Natural Features and Wetland Report for the Grandview Reserve Project in El Paso County, Colorado

August 12, 2020

Ecosystem Services, LLC
Response to El Paso County Comments
Regarding The
Natural Features and Wetland Report (Report) for the
Grandview Reserve Project
in El Paso County, Colorado

Responses to County Comments RE: April 10, 2020 Report:

SKP-20-001  
 SHEET SP1.2 2

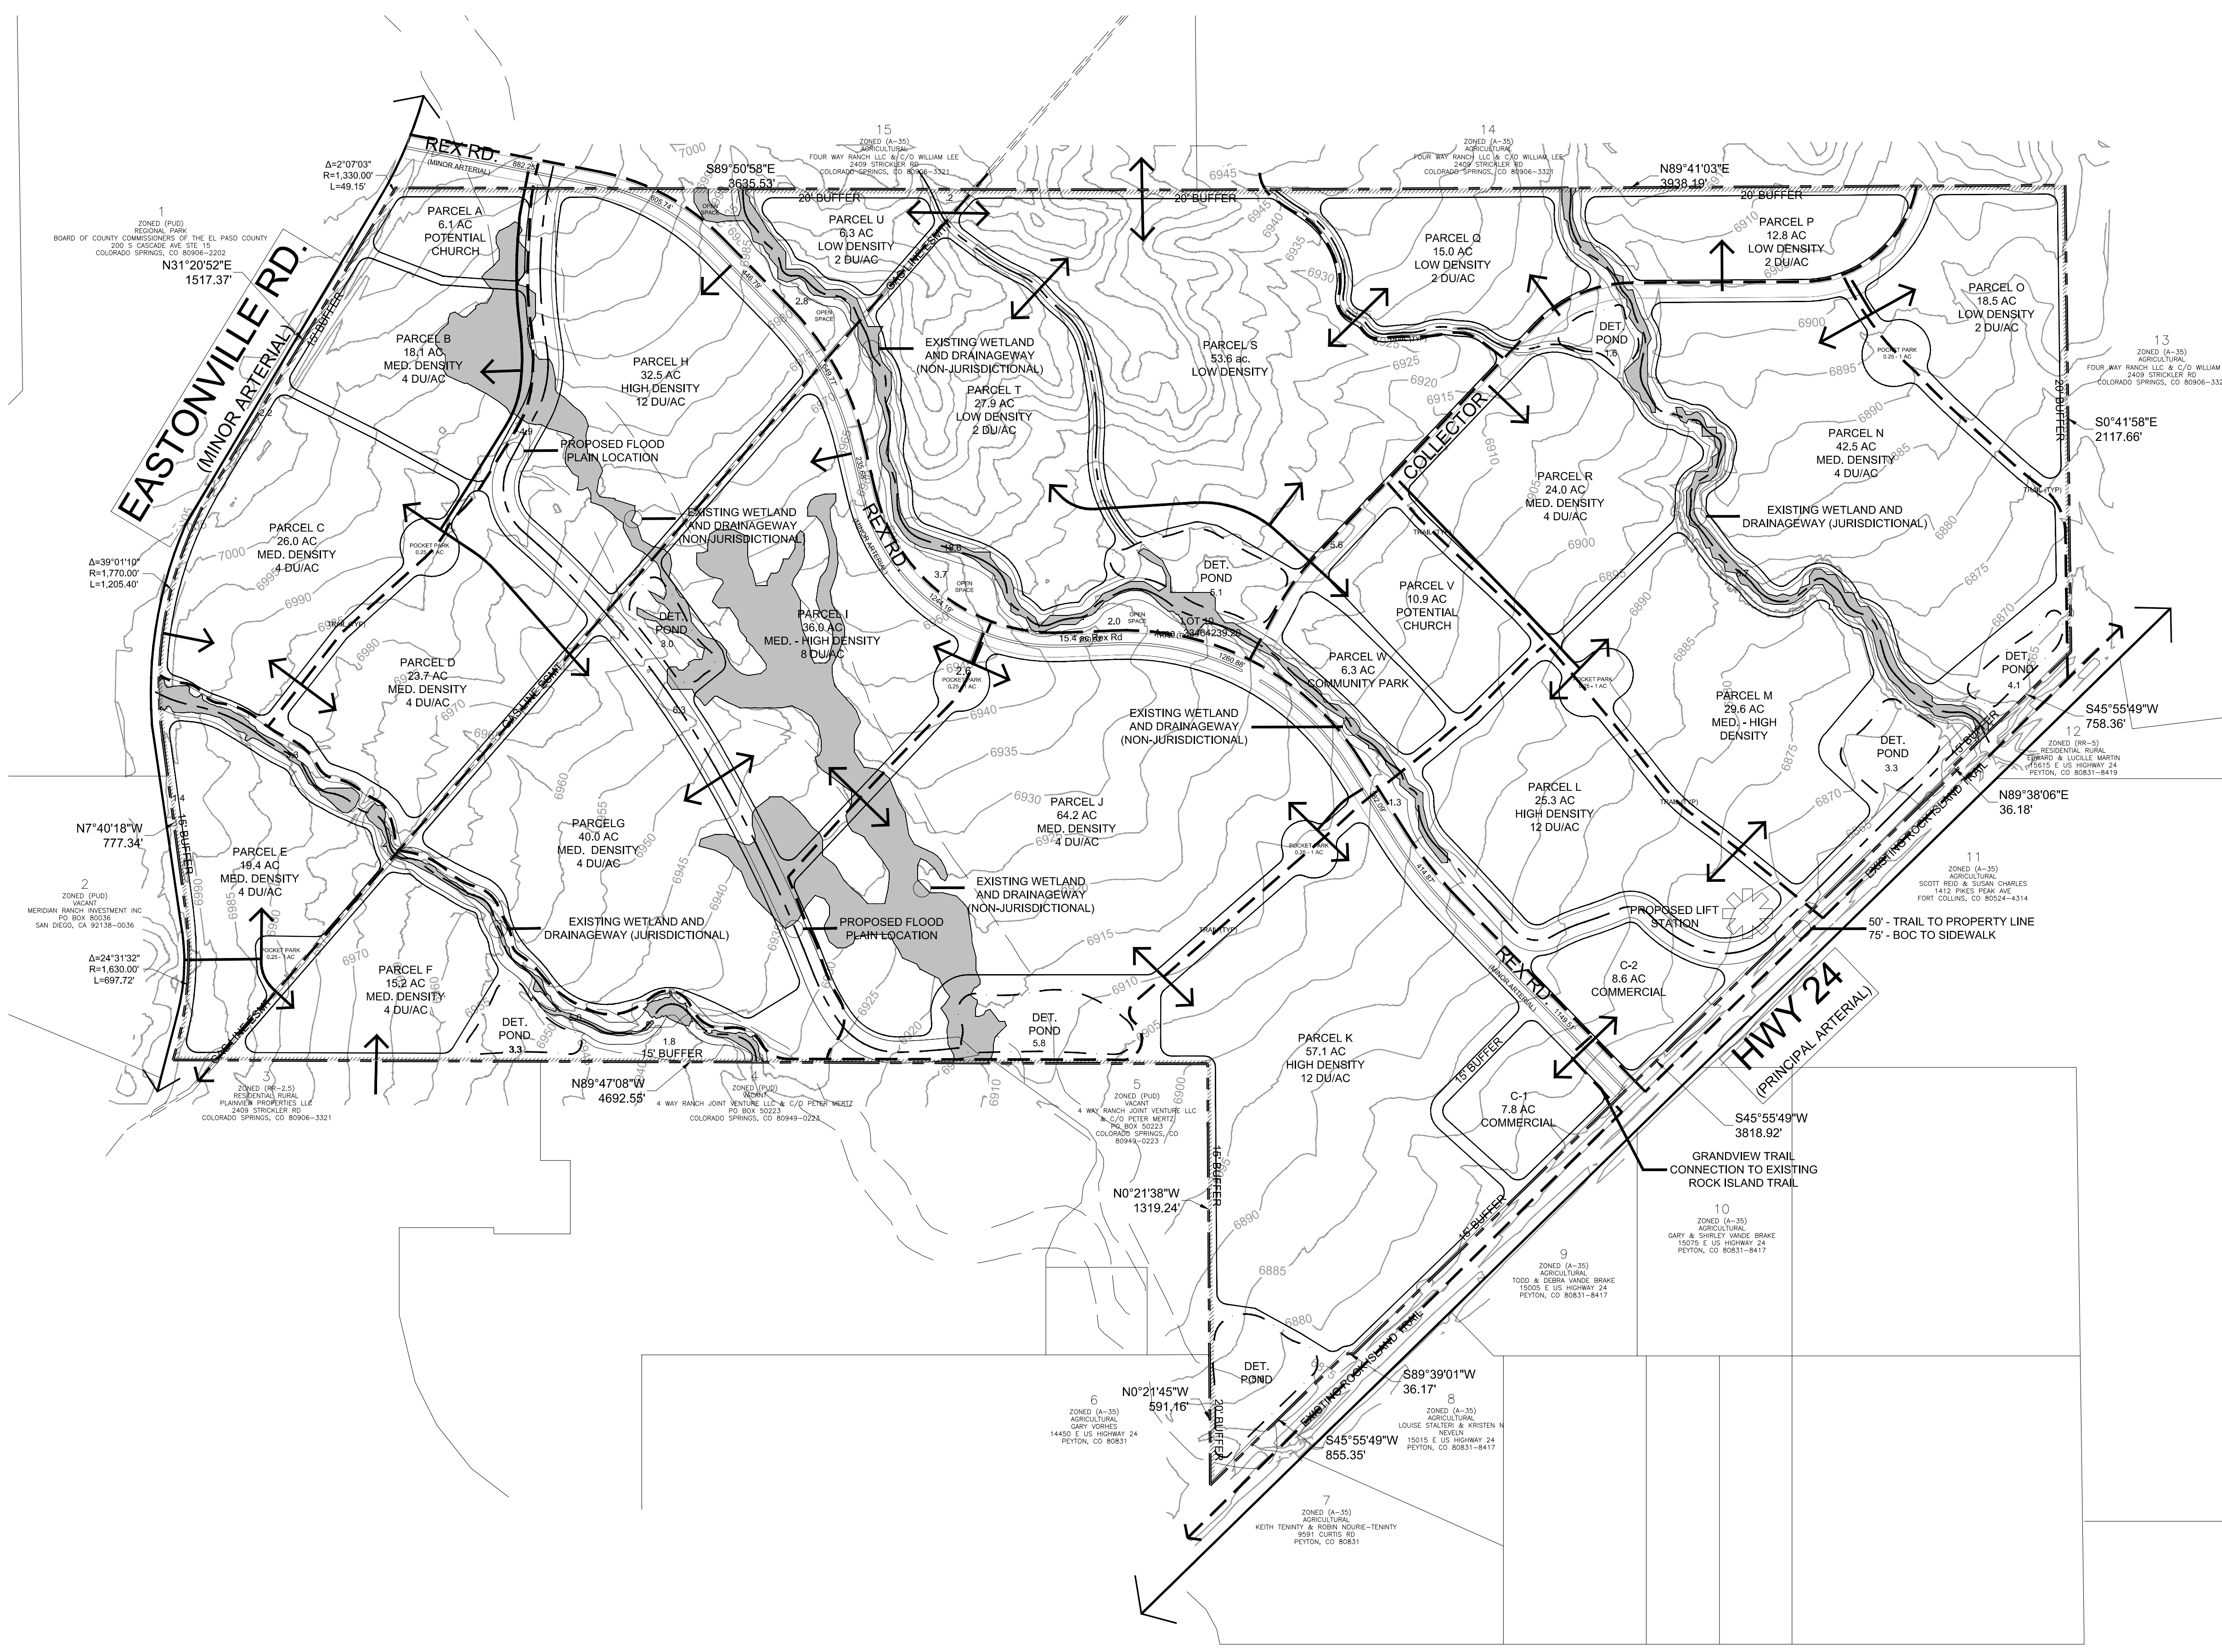
Based on the explanation above Ecos did not make any revisions regarding ULTO, however we did insert the new Figure 2 Sketch Plan HR Green prepared that better illustrates topography (per other County comments). Our detailed response to each of the County comments are below:

- Page 12, Section 3.4 Wetland Habitat and Waters of the U.S., Sub-section 3.4.2 Field Assessment Findings, items 1) Jurisdictional wetland habitat and waters of the U.S. and 2) Non-Jurisdictional, Isolated Wetlands –Label each on figures”. The County has requested that we label the applicable figures to indicate which Drainages are Jurisdictional and Non-Jurisdictional. Figure 6 on page 15 is the only Figure referenced in this section and the only one that represents the content of the County comments; and Figure 6 clearly labels each Drainage by alpha designation (A – D) and Jurisdictional and Non-Jurisdictional status.
